**From:** Paton, Julie <Julie.Paton@lancashire.gov.uk>  
**Sent:** 22 August 2024 15:21  
**To:** Planning  
**Subject:** 3/2024/0573 Hall Barns Farm Knowles Brow Hurst Green BB7 9PT  
**Attachments:** 3 2024 0573 Overlay.pdf

**Reference** 3/2024/0573  
**Location** Hall Barns Farm Knowles Brow Hurst Green BB7 9PT  
**Proposal** Proposed removal and reinstatement of concrete agricultural track and hardstanding.

EXISTING AND PROPOSED SECTION DETAILS

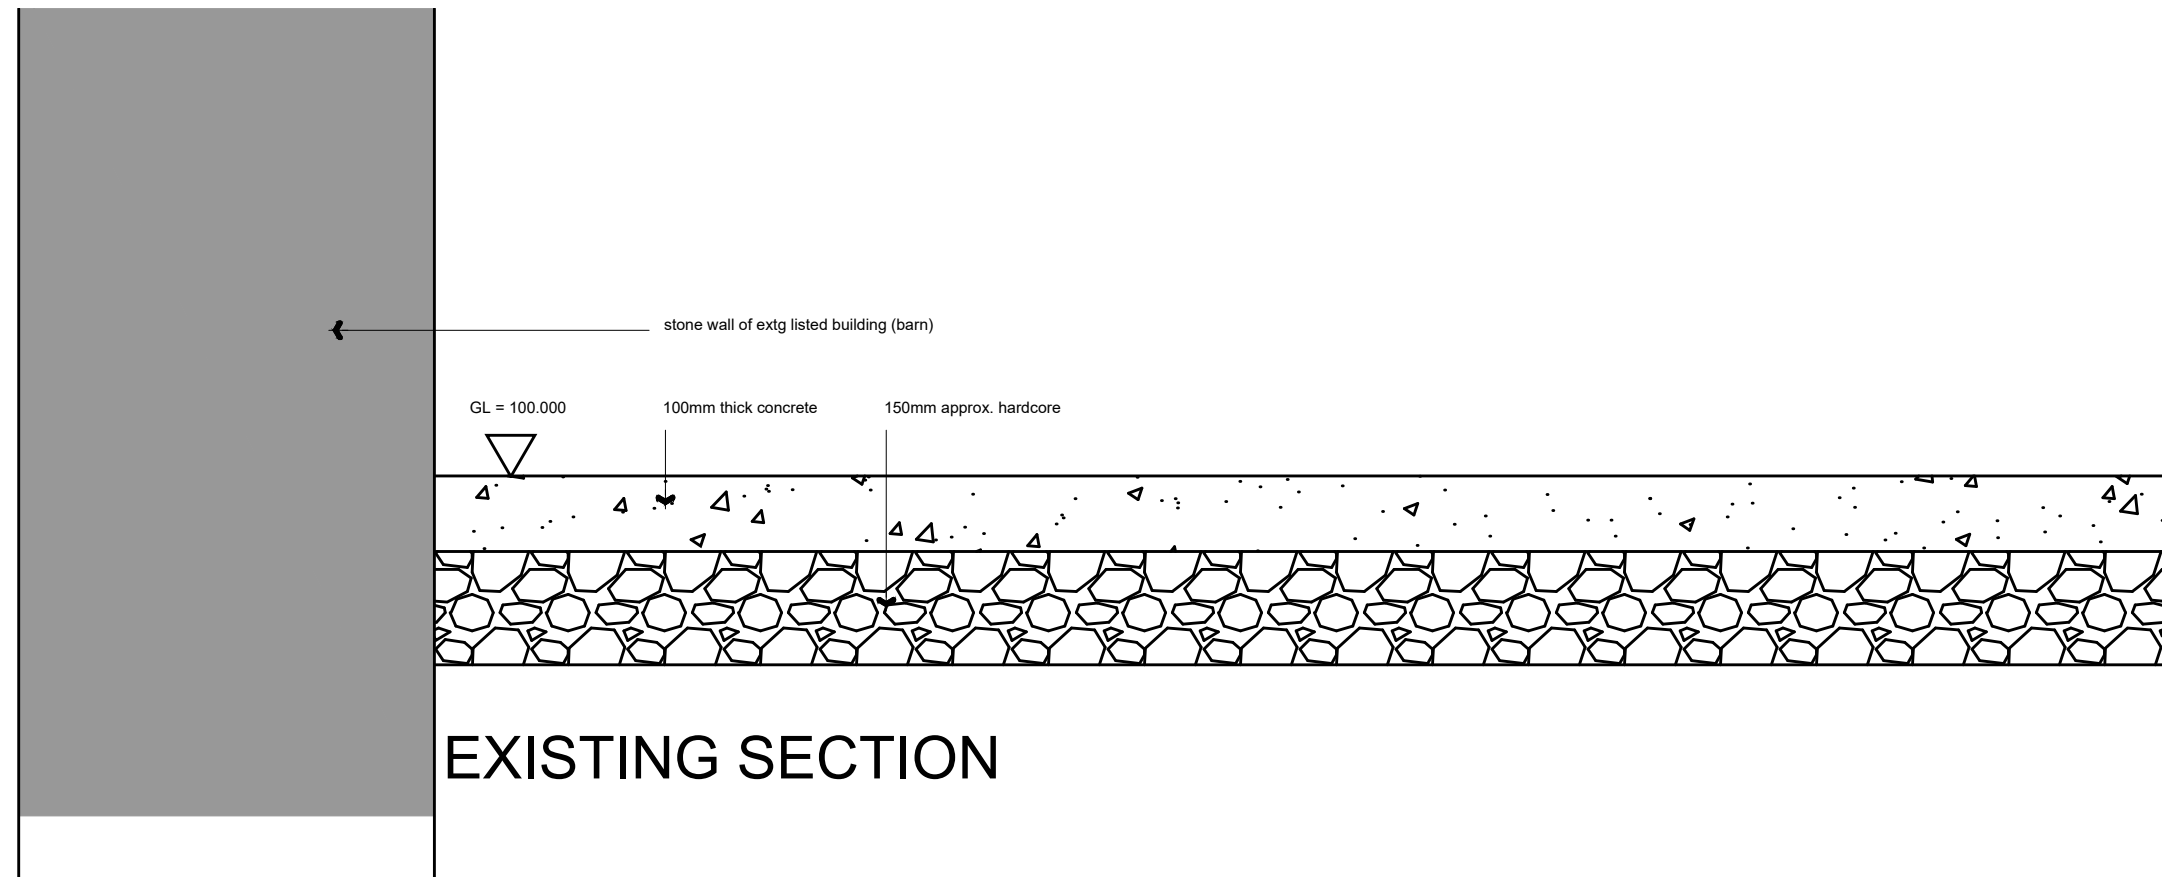
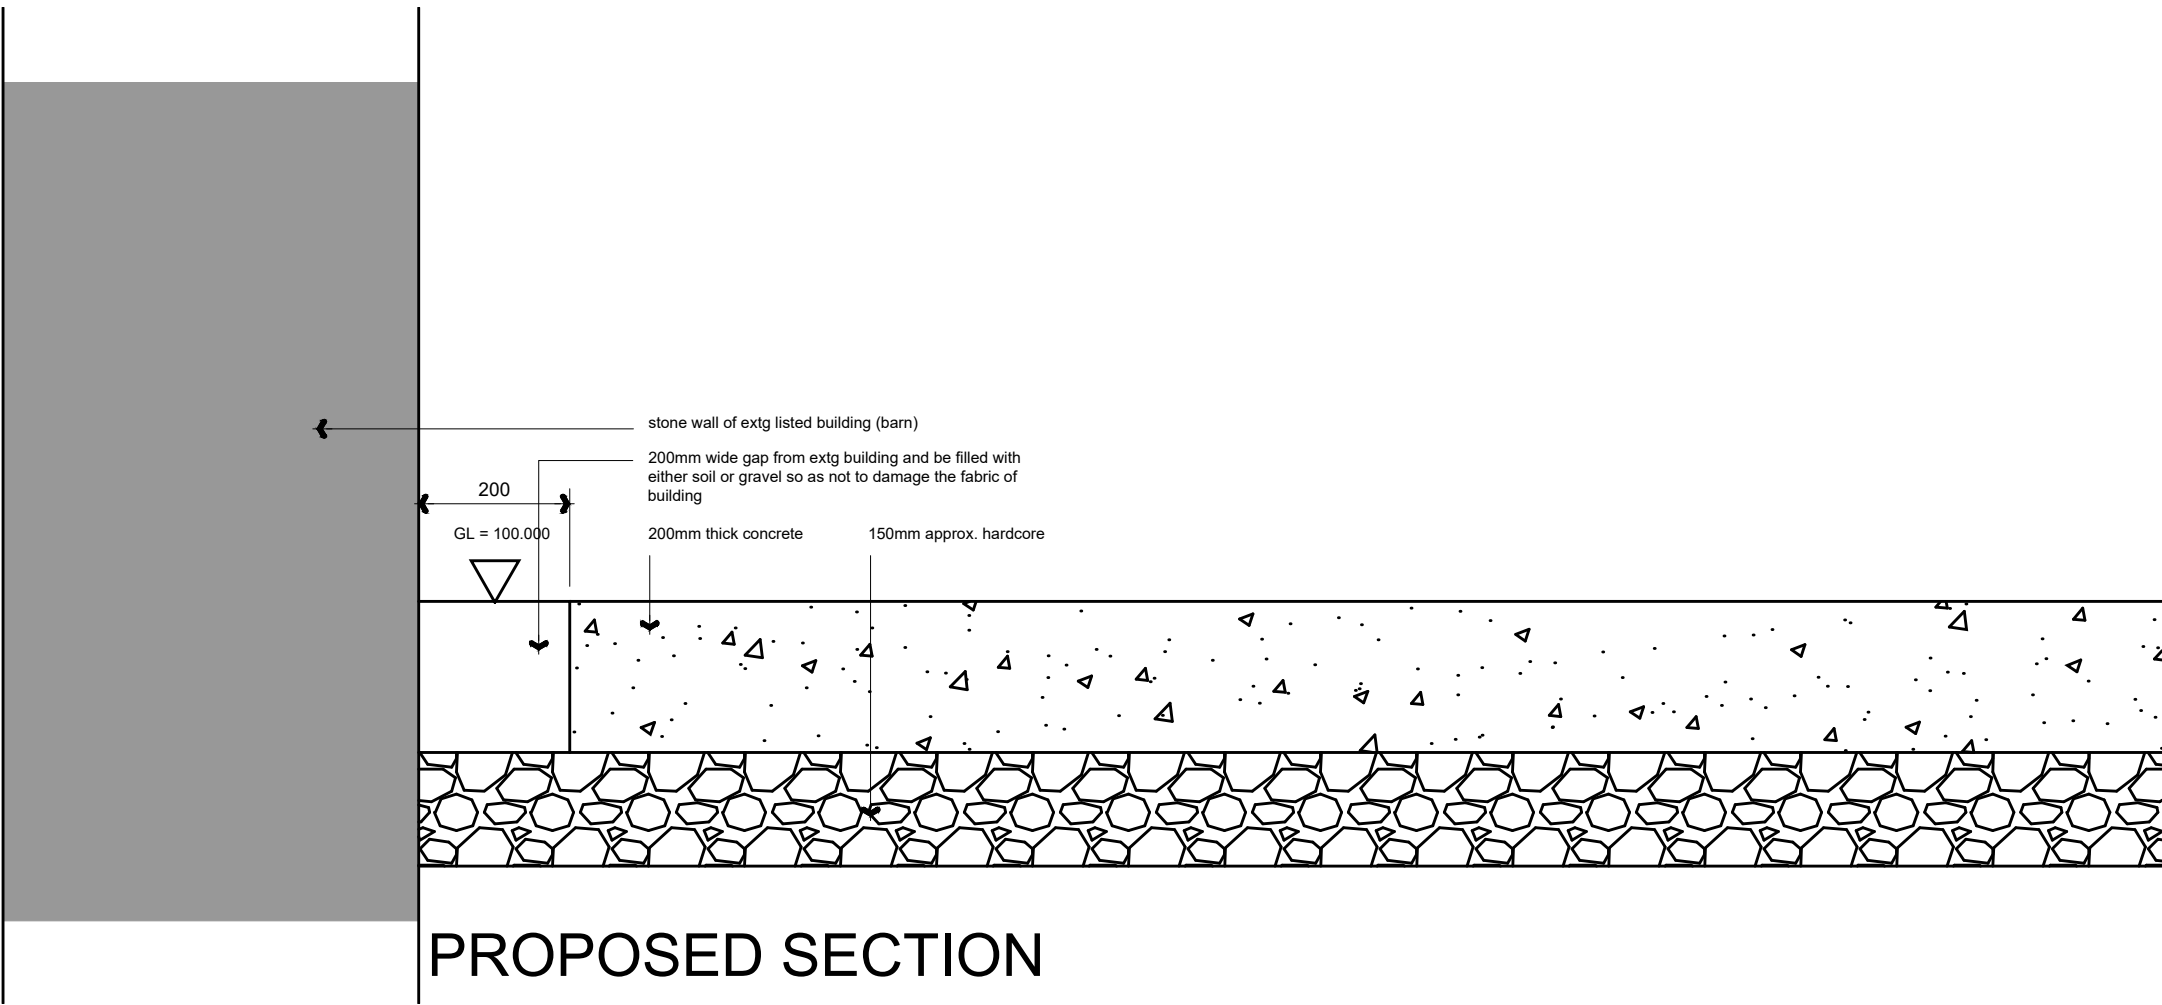
Any changes in ground level or installation of drainage should ensure that surface water is not discharged onto a public right of way either within the proposed development site or in close proximity – this is to ensure public rights of way are not exposed to potential flooding or future maintenance issues.
